610.17382.00100-L02-v0.2 20190702.docx

Mercantile Hotel - Refurbishment & Rooftop Terrace (SSD-8665)
Noise Assessment
Ground Floor Courtyard

Drawing No.
SSDA 102

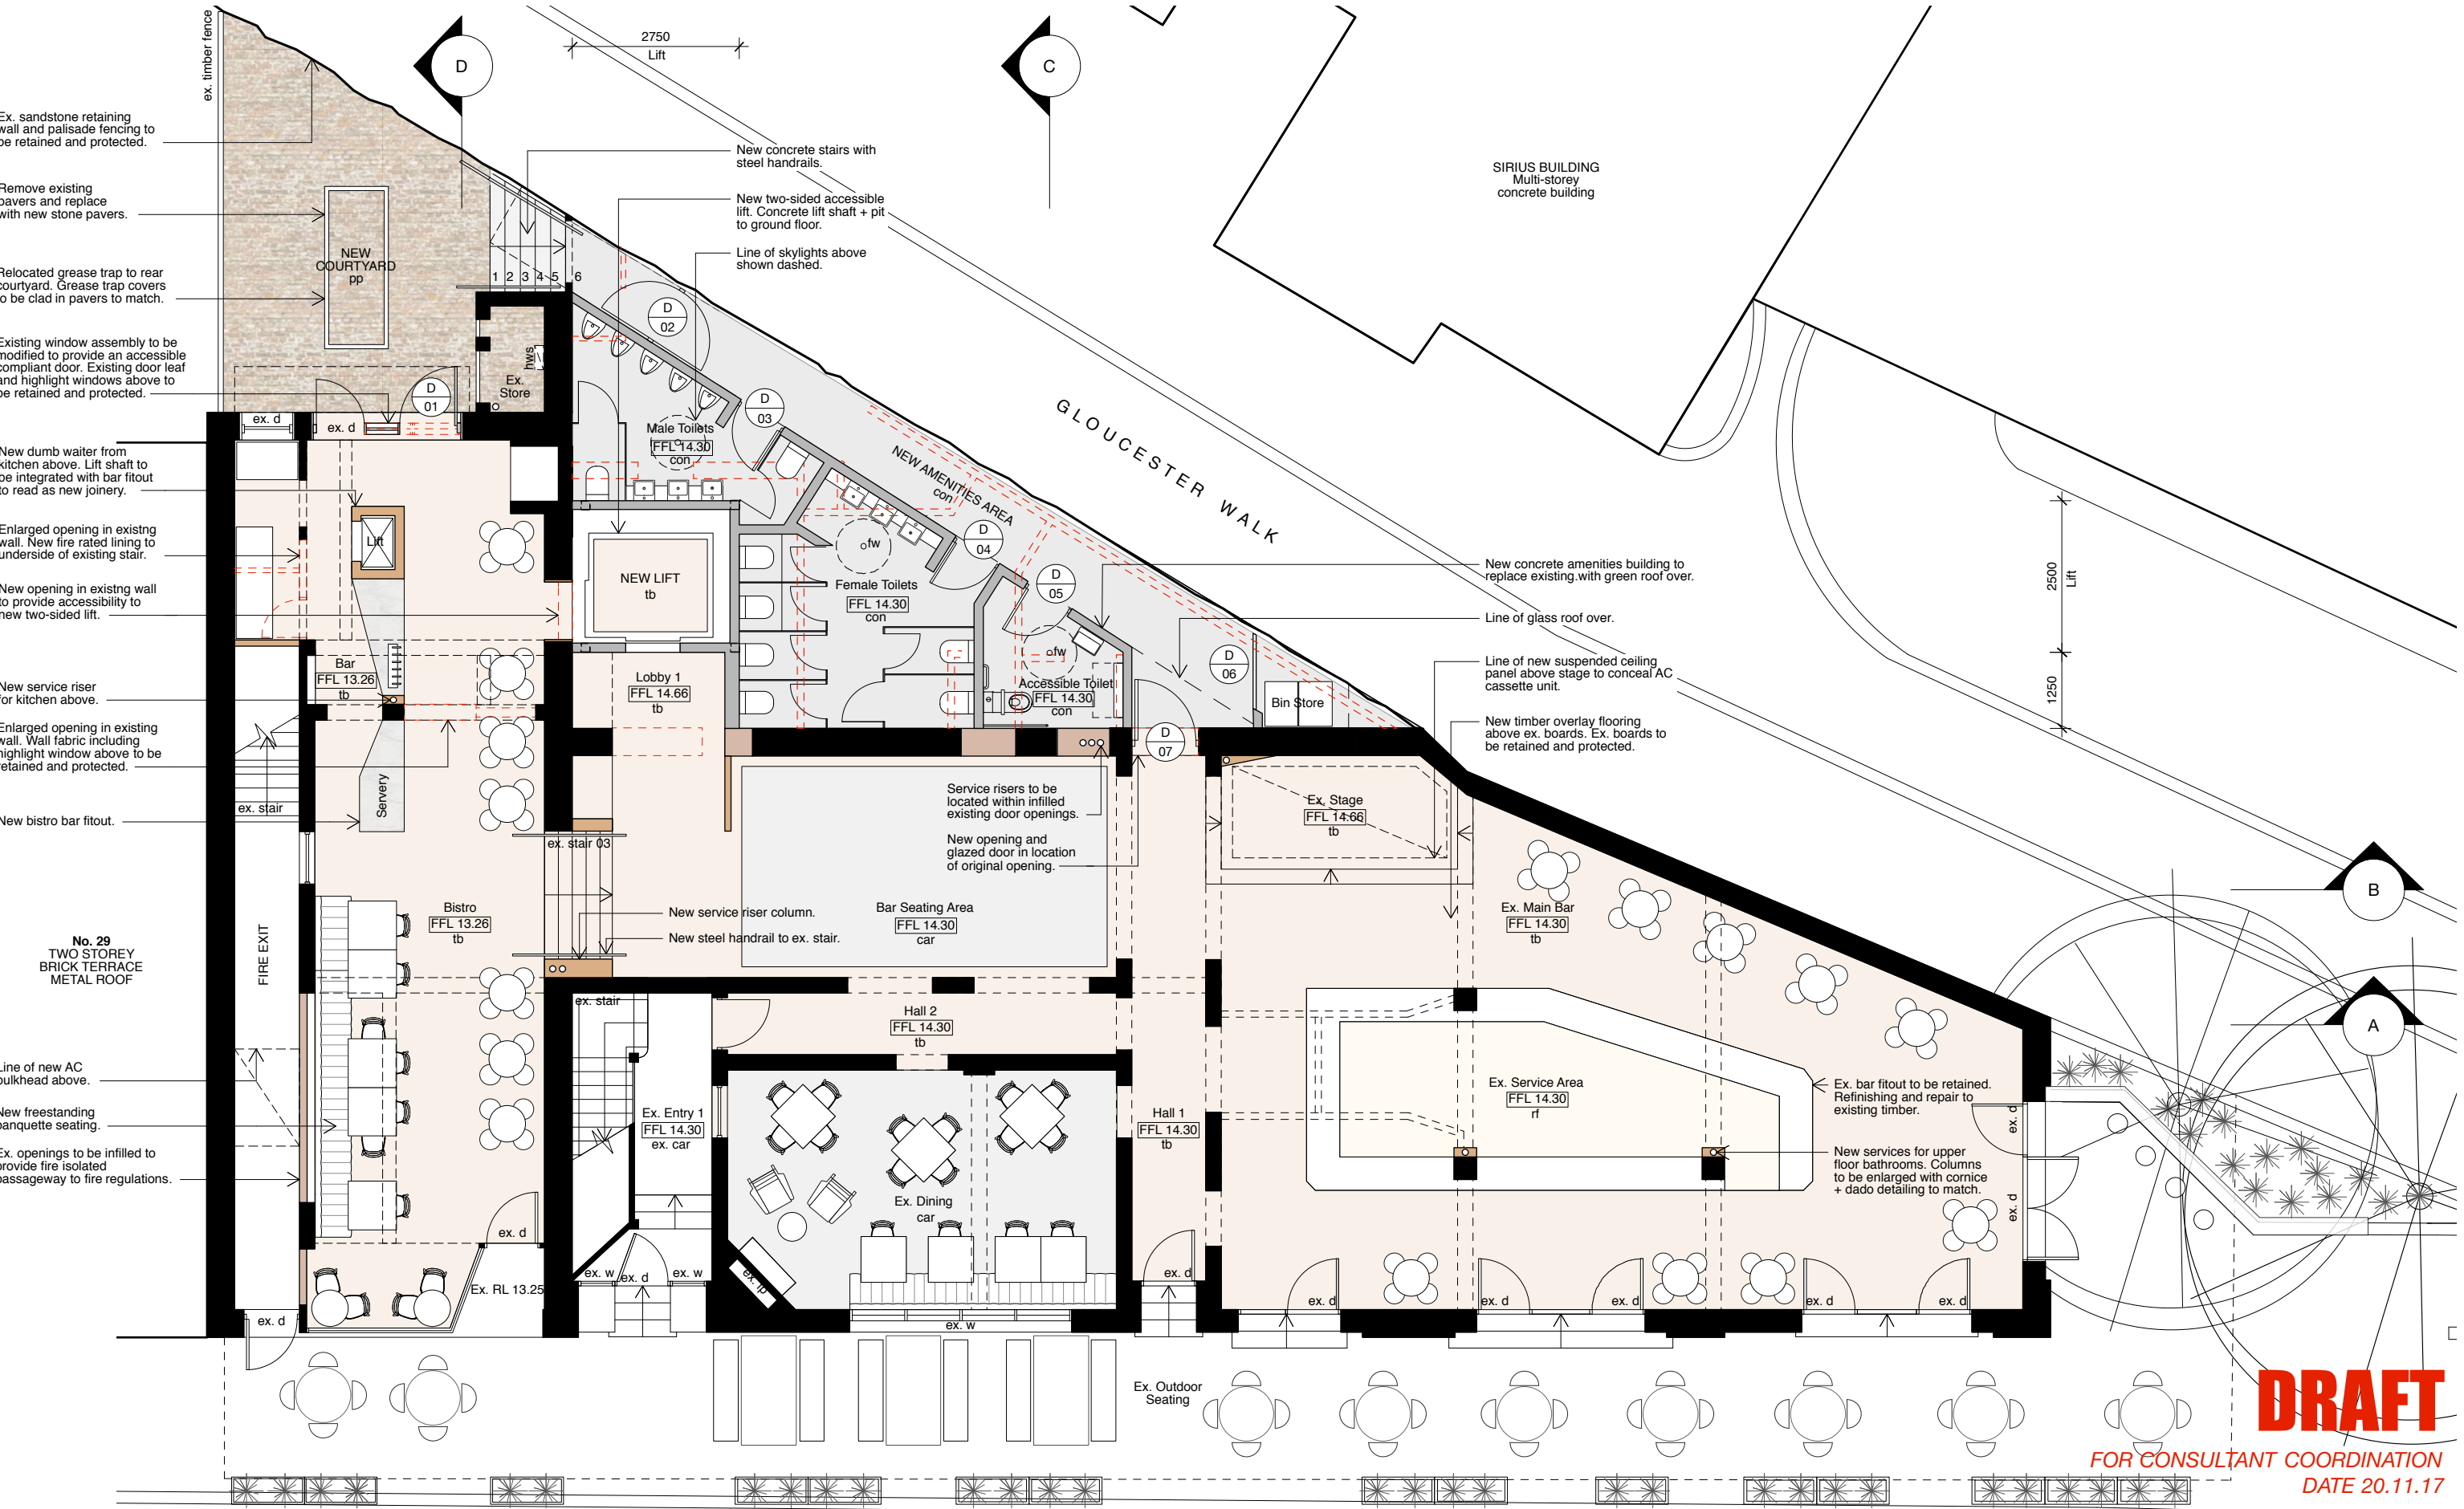
- *Confirm an allowance has been made in the Noise Assessment for noise impacts associated with the ground floor courtyard.*

The courtyard area will be used by diners of the attached ground floor bistro. It is a relatively small area seating up to 16 diners and it is understood that the operating times will be consistent with other areas of the venue, ie 10:00 am to midnight Monday to Saturday, till 10:00 pm Sunday. Entertainment or amplified music will not be provided to the courtyard.

The nearest sensitive receptors to the courtyard will be those on Cumberland Street. However, the courtyard will be well below the local ground level of those receptors, ie the courtyard will be housed within retaining walls that would provide substantial noise screening towards the sensitive receptors.

Based on the separation distance to the nearest sensitive receptors, and the location and proposed use of the courtyard, the predicted noise level from the courtyard when fully occupied would be approximately 43 dBA. That level would not be considered significant in the context of the existing ambient noise environment and would not be expected to contribute to the overall venue noise emissions observed at the nearby sensitive receptors.

Therefore no further assessment or allowance for the ground floor courtyard would be required.
